Our Ref: 2025/459047

The New Forest High School - Modification 3 - Staged Public Domain and Roadworks (SSD-26876801-Mod-3)

APPENDIX 1 - DETAILED TRAFFIC COMMENTS FOR SSD-26876801 NORTHERN BEACHES COUNCIL

ALLAMBIE ROAD KISS AND DROP SPACES
- 40kmhr speed
- AUSTRADS PART 3
-MGSD checks
TOTAL LENGTH - **55m**

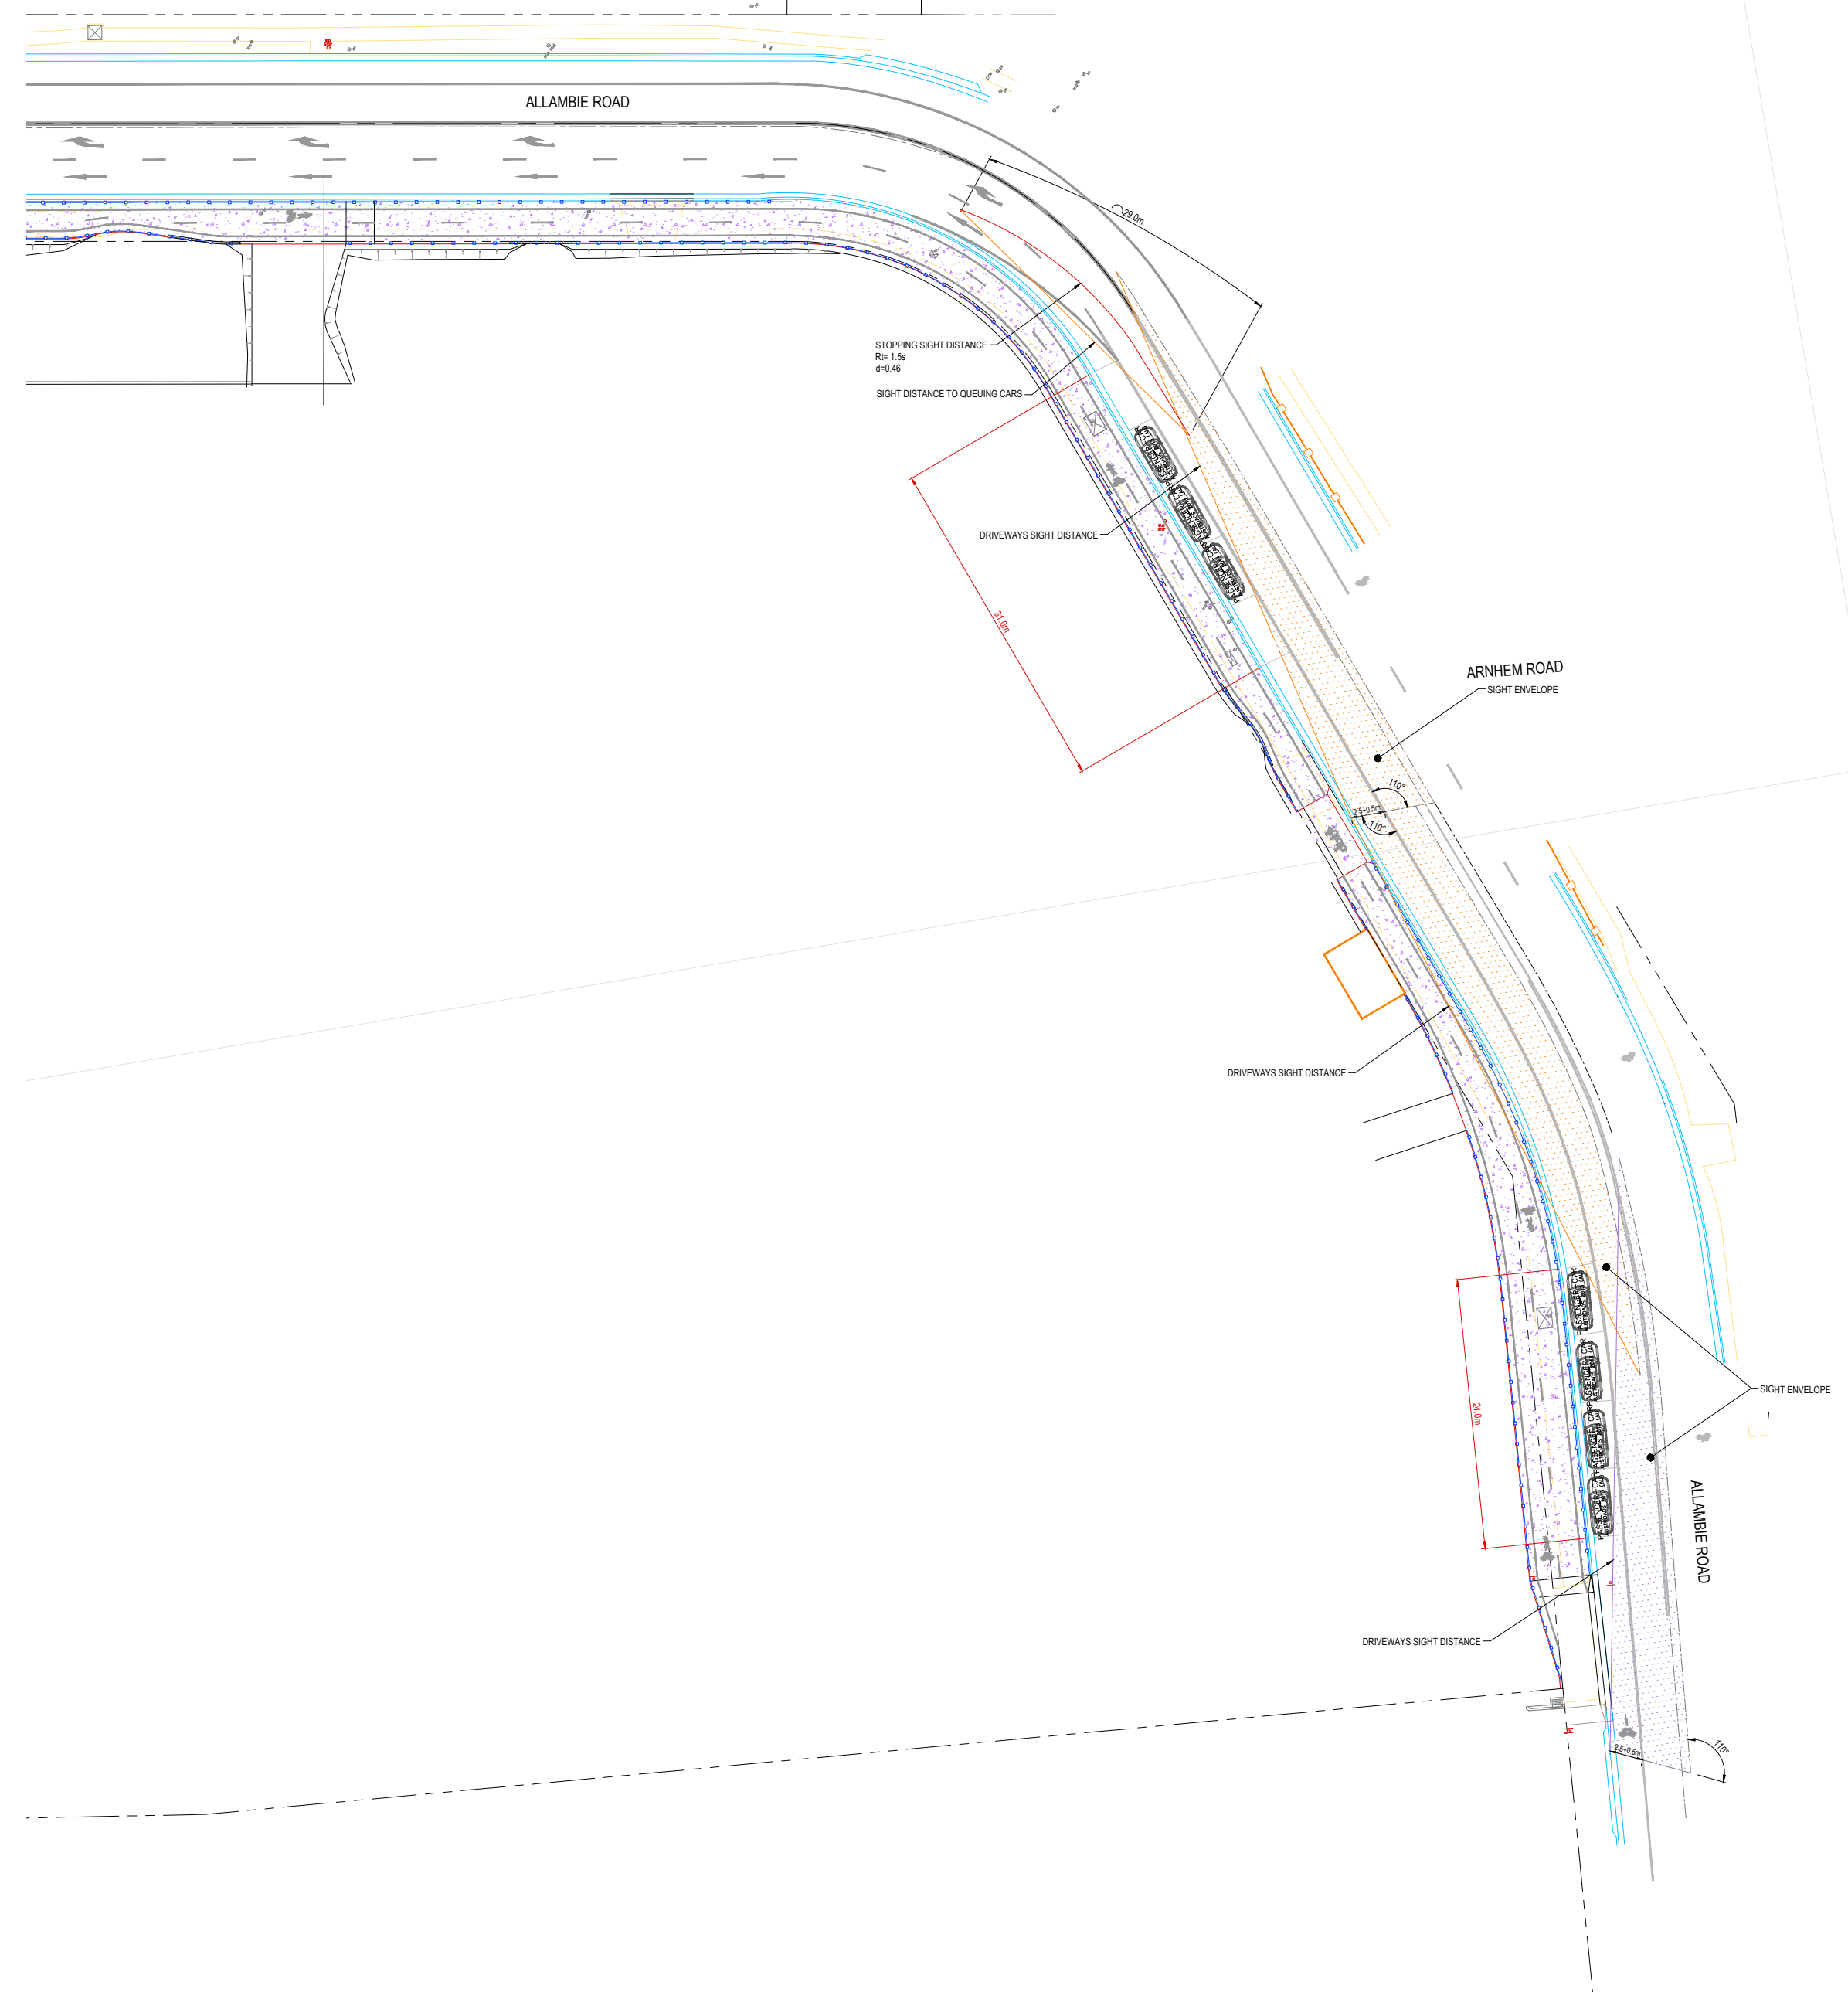
- The proponent is now showing 7 kiss and drop spaces along Allambie Road. These are not supported by Council on safety grounds.
- The proponent is suggesting a delay in providing an upgrade of Aquatic Drive and Allambie Road for up to 2 years or until the school population hits 1200 students. This is not supported by Council. The proponent is proposing a second modification application to remove the signalised treatment of the intersection and replacing it with an upgraded roundabout. Whilst this is not the safest option for the location from a vulnerable road user perspective both Council and TfNSW have accepted this outcome prior to school opening. The concern is that the interim solution that is proposed by this modification may be left in place for a longer timeframe than is expected through an additional modification process once the school is operating.

## PUBLIC DOMAIN PLAN - STAGE 1

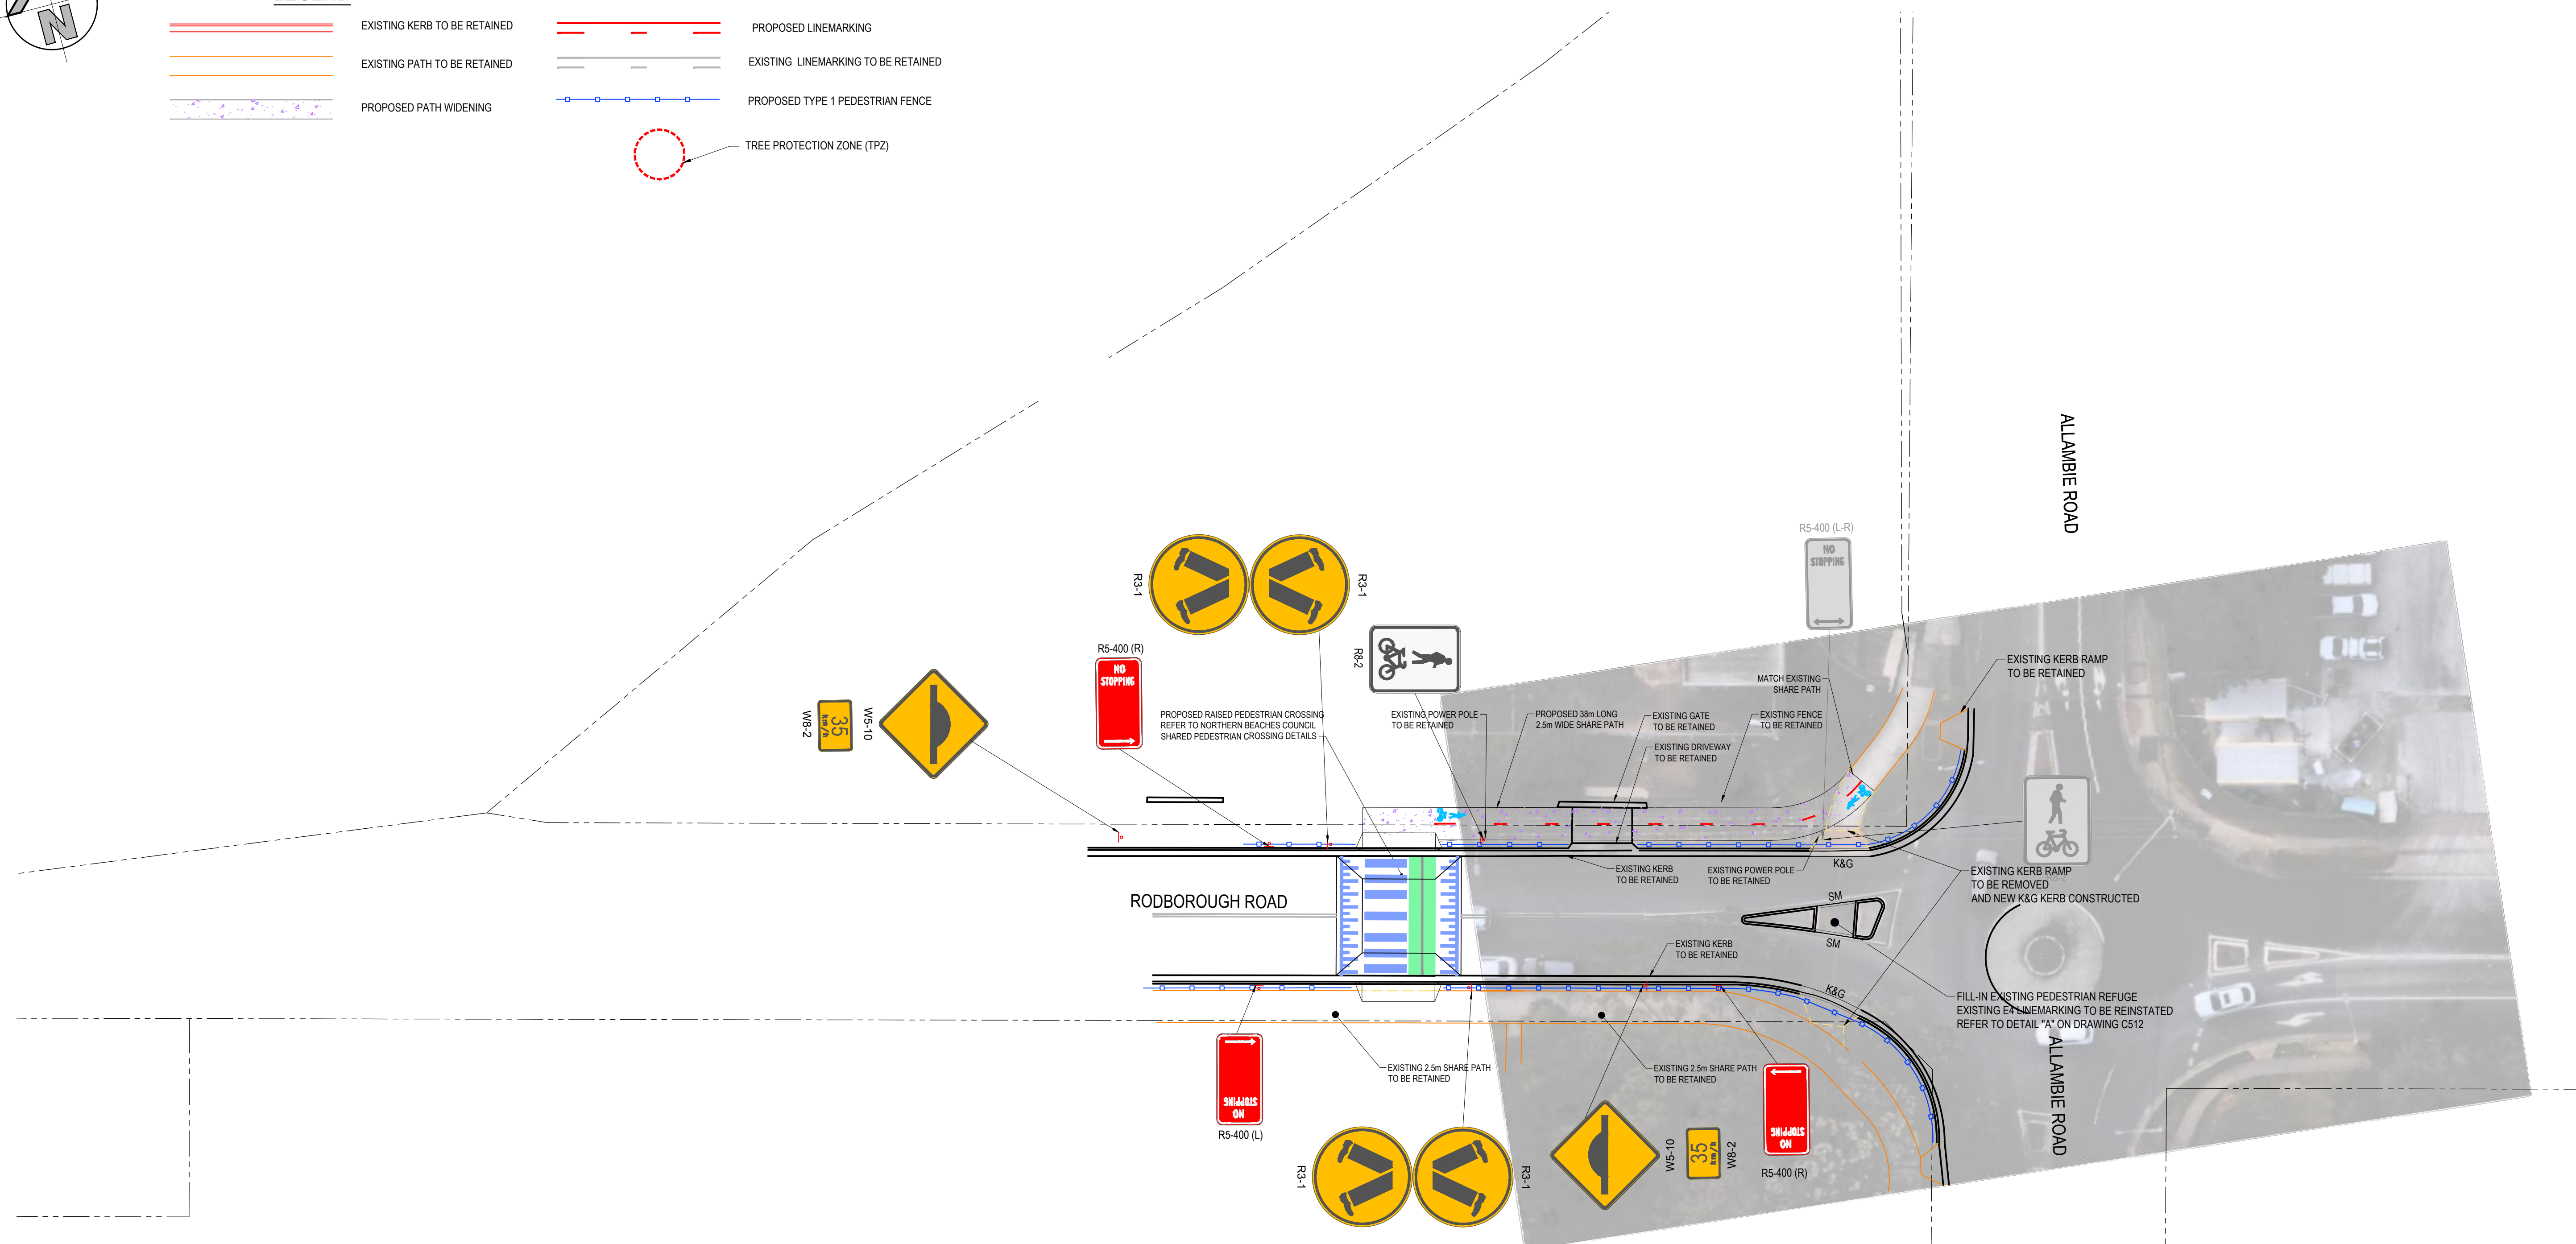
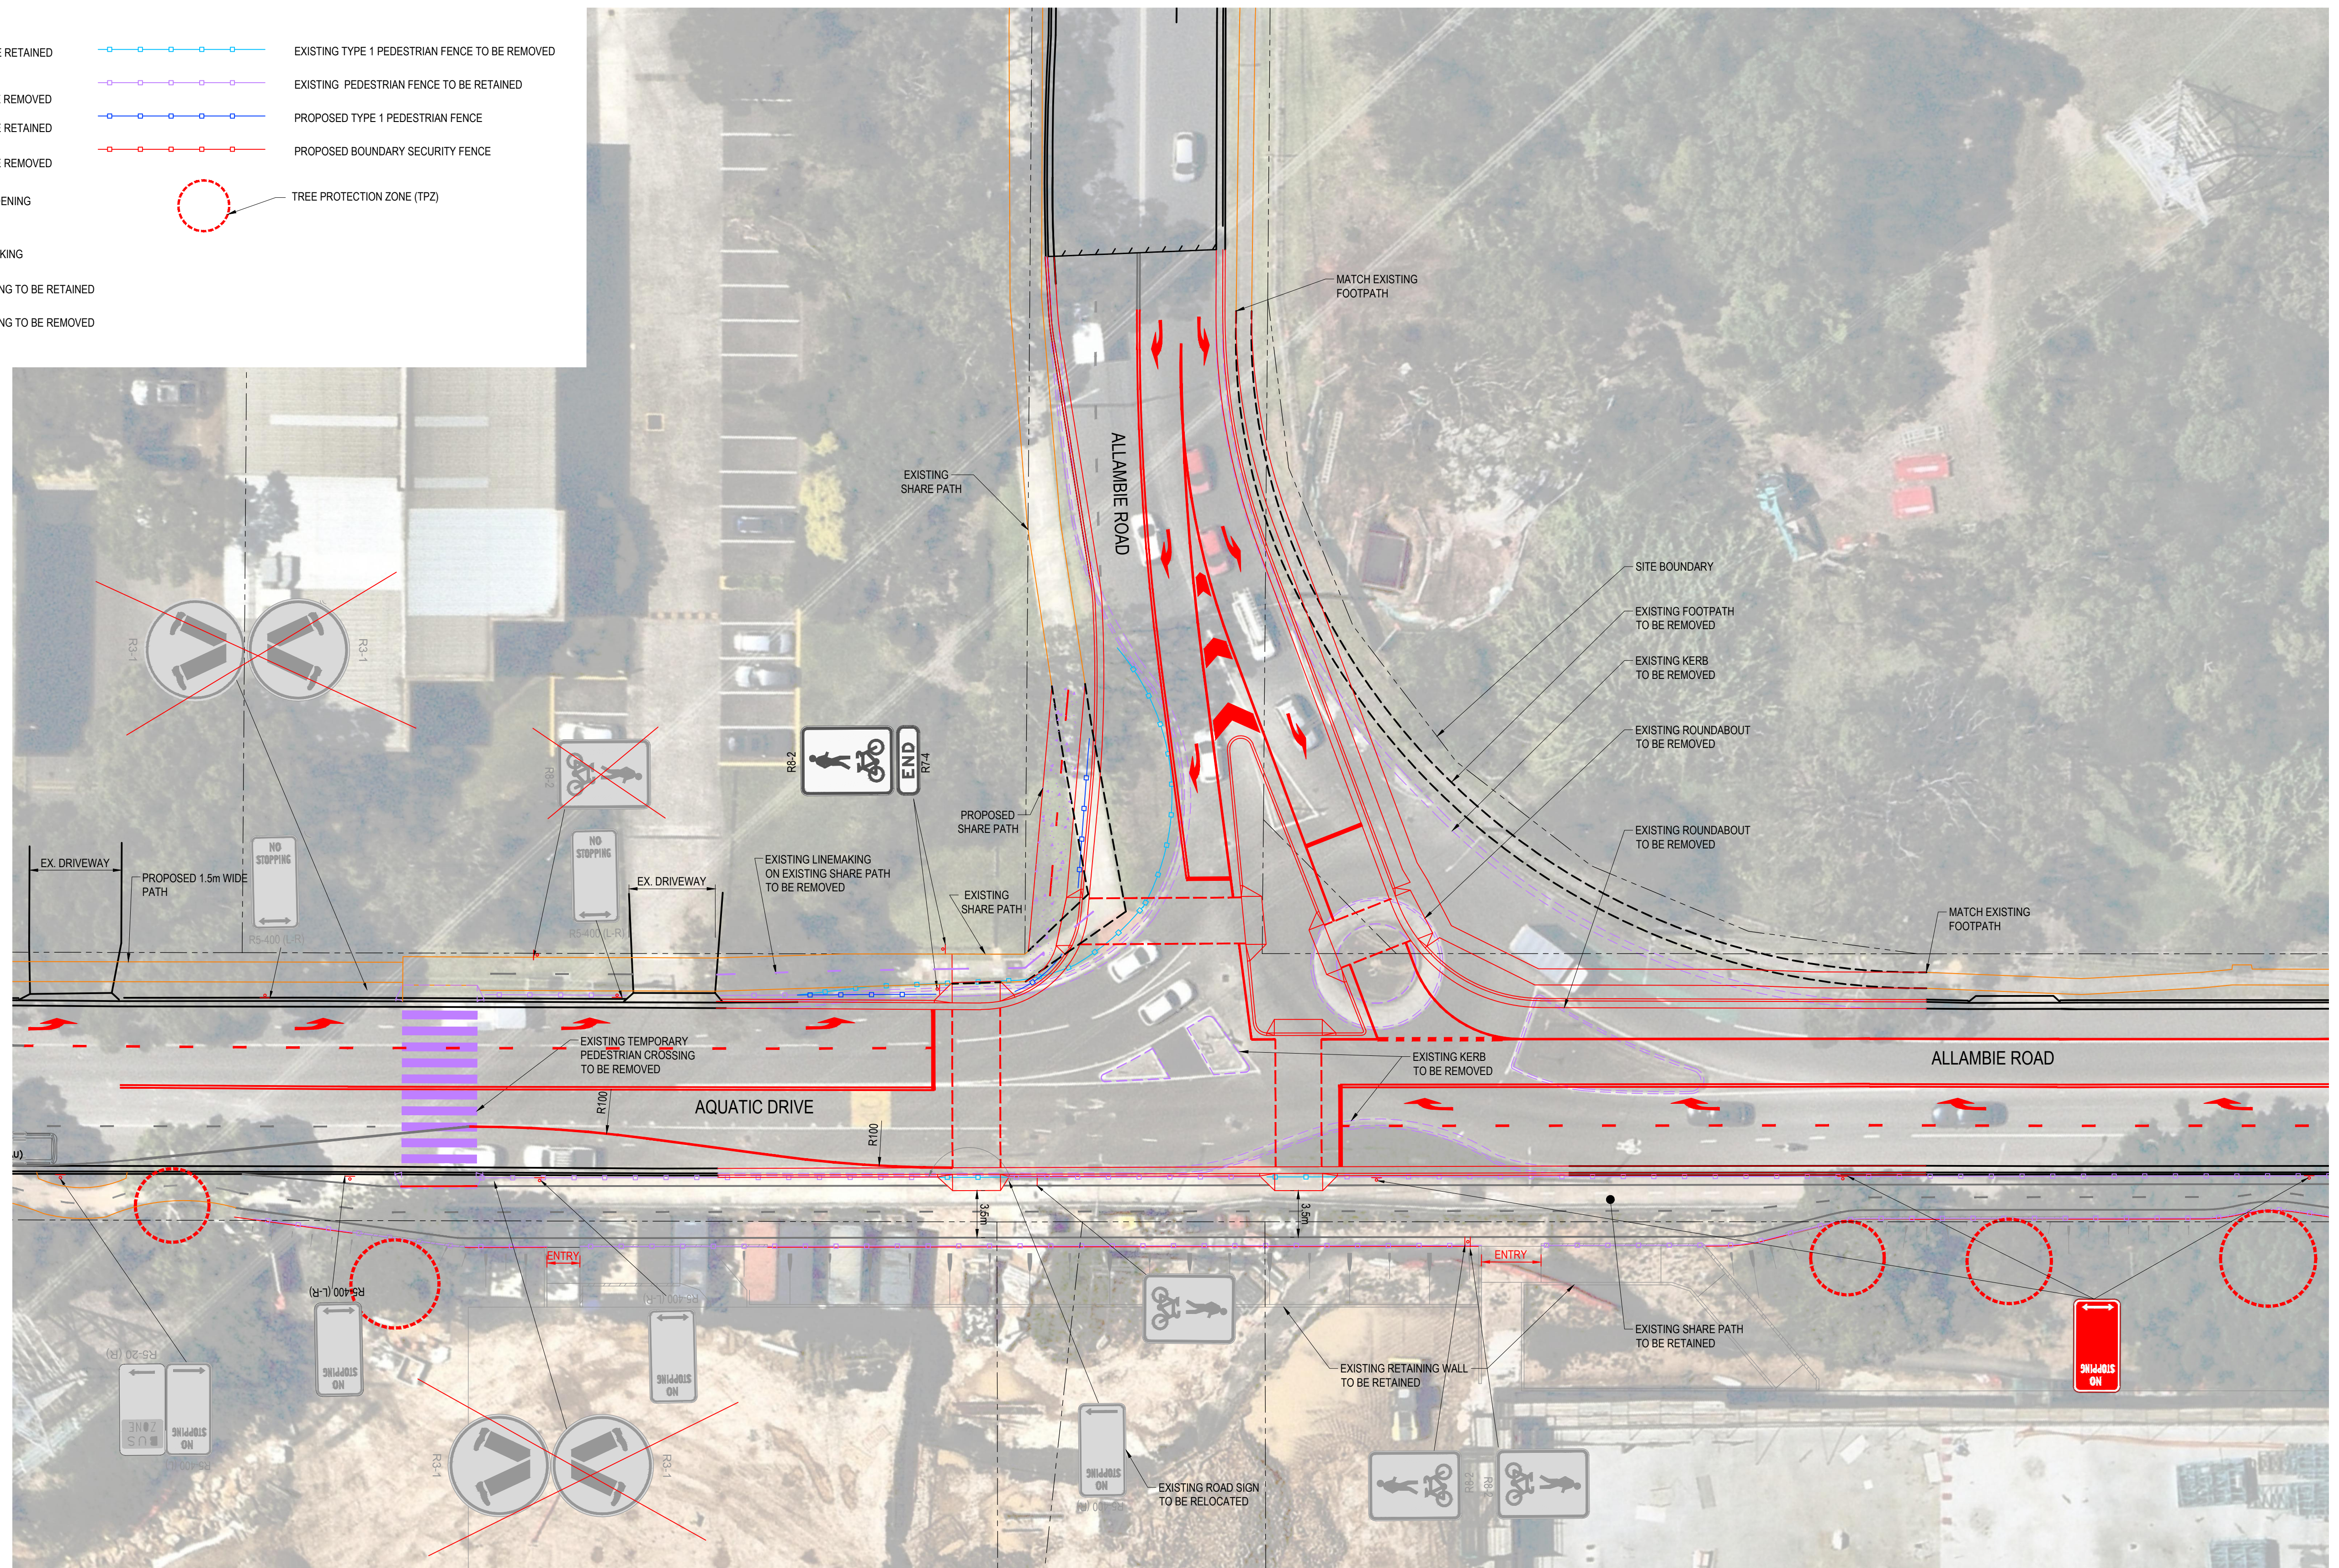
- Council has requested a 4-metre minimum shared user path for the full frontage of the subject site. The proponent has dismissed this request even though Council has provided a design to demonstrate that it can work and is supported in principle by TfNSW.

4. *Endorses the concept plan (Attachment 3 Option 6a_25.03.25) for the provision of a 4-metre-wide shared user path inclusive of the realignment of the southern kerb along the Allambie Road frontage and associated road pavement works, subject to the provision of detailed design and supporting Road Safety Audit for consideration of Council and TfNSW prior to approval under Section 138 of the Roads Act 1993 by the relevant Roads Authority.*
